**Re: Future Music Festival 2013, Royal Randwick Racecourse (SSD 5394-2012)
Notice of Exhibition**

The Transport Management Centre received a Notice of Exhibition from Karen Jones, Director, Metropolitan & Regional Projects South, dated 12 November 2012 regarding a proposal lodged by the event organiser of Future Music Festival 2013.

A review of the event organiser's Traffic and Transport Management Plan (TMP) draft version 2.0 dated 11 September 2012 has been made, against the minimum requirements and inclusions of the event proponent's TMP outlined in the request for Director-General's Requirements letter dated 9 August 2012.

FIGURE 3 – PROPOSED EVENT LAYOUT

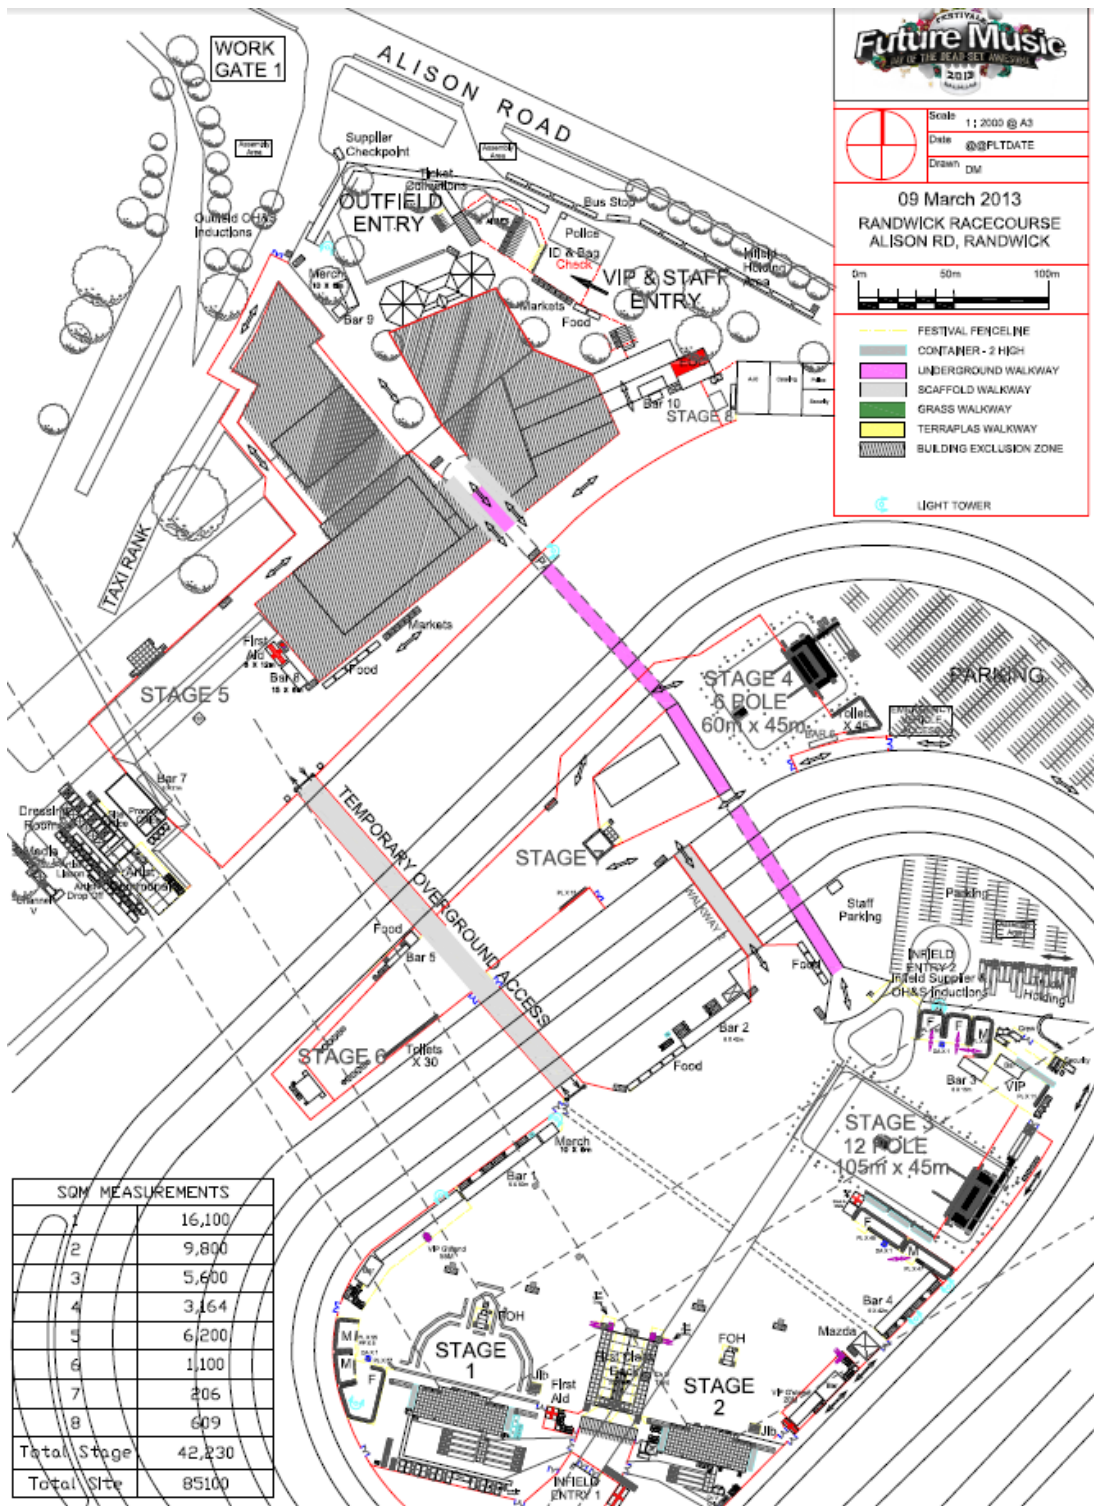
8. A venue site plan detailing how patrons are transitioned from the external Traffic and Transport Management Plan into the venue on ingress, including placement of wayfinding resource and signage

9. A venue site plan detailing how patrons are transitioned from the venue out to the external Traffic and Transport Management Plan on egress, including placement of wayfinding resource and signage

The draft version 2.0 TMP is acceptable if the event is capped at 45,000 participants. The issues and risks outlined above need to be resolved if approval for 50,000 participants is sought.
